DECISION DELEGATED TO HEAD OF PLANNING

Application No: H22-1064-23 **Applicant:** Highgrove Homes (Spalding) Ltd

Proposal: Details of landscaping, tree planting & boundary treatments (Conditions 4 & 7 of H22-0894-23)

Location: Adjacent To 2 Fengate Drove Weston Hills Spalding

Proposed Site Layout
Scale 1:200

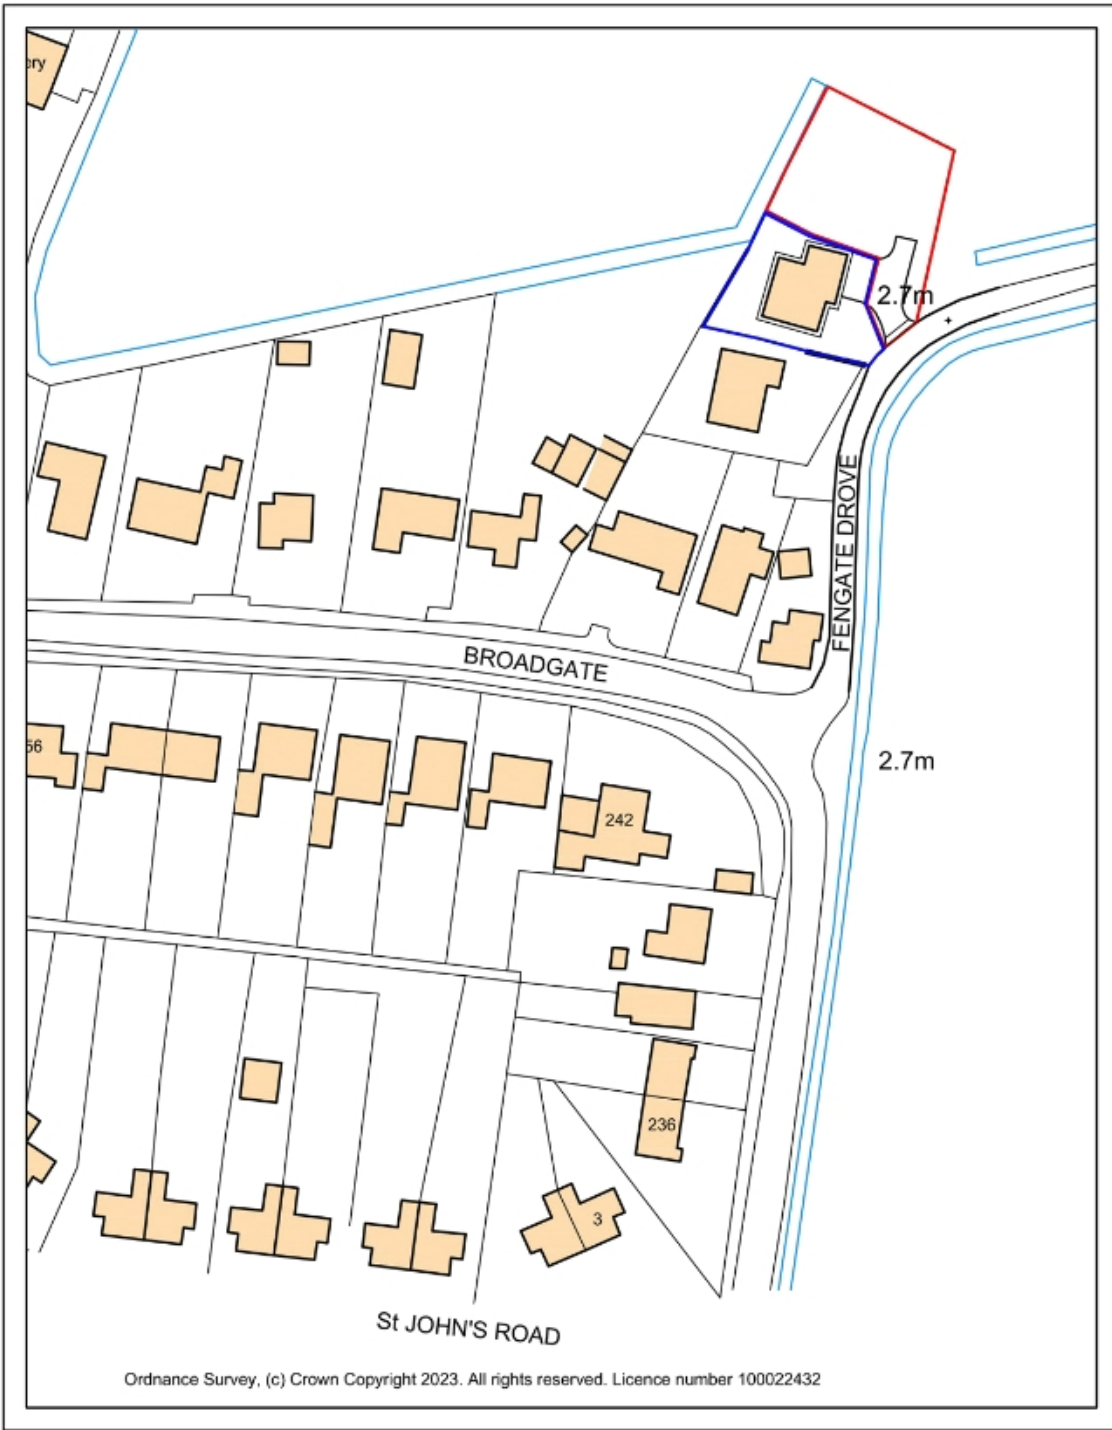
The area surrounding the dwelling is of course grassed as this will be the amenity space for the residents. The details illustrate that there shall be no tree planting on site; however, there is still adequate landscaping details provided within this application.

The scheme includes a 2650mm hedge on the eastern boundary running parallel to Fence Type B on this side, with Phormium plants located to the front of the proposed bungalow. This is therefore an adequate amount of green area and foliage within the site to satisfy this condition and requirement. Alongside this, there shall be one bat box and swift nest brick within the site to provide suitable habitats for animals to safely reside if needed. The details are therefore considered to be acceptable.

The details illustrate the proposed use of four separate boundary treatments throughout the site. Fence Type A runs 23000mm along the western boundary and 23500mm along the northern boundary, this is a 1.2m high feather board fence.

Fence Type B runs 26500mm along the eastern side which is also 1.2m in height, but is a post and rail fence (this is the fence closest to the highway).

Finally, Fence Type C & D are both on the southern side closest to the neighbouring property; type C is a timber knee rail running around 6000mm with Type D being a feather board fence of 1.83m height and having a total length of 8500mm, with an adjacent section being around 4500mm to provide additional cover and privacy to the neighbouring property. There are a variety of designs of boundary treatments in the immediate area and therefore these styles are acceptable and has no impact on highway safety.

Condition 4 of H22-0894-23 can therefore be discharged.

Condition 7 of H22-0894-23 can therefore be discharged.
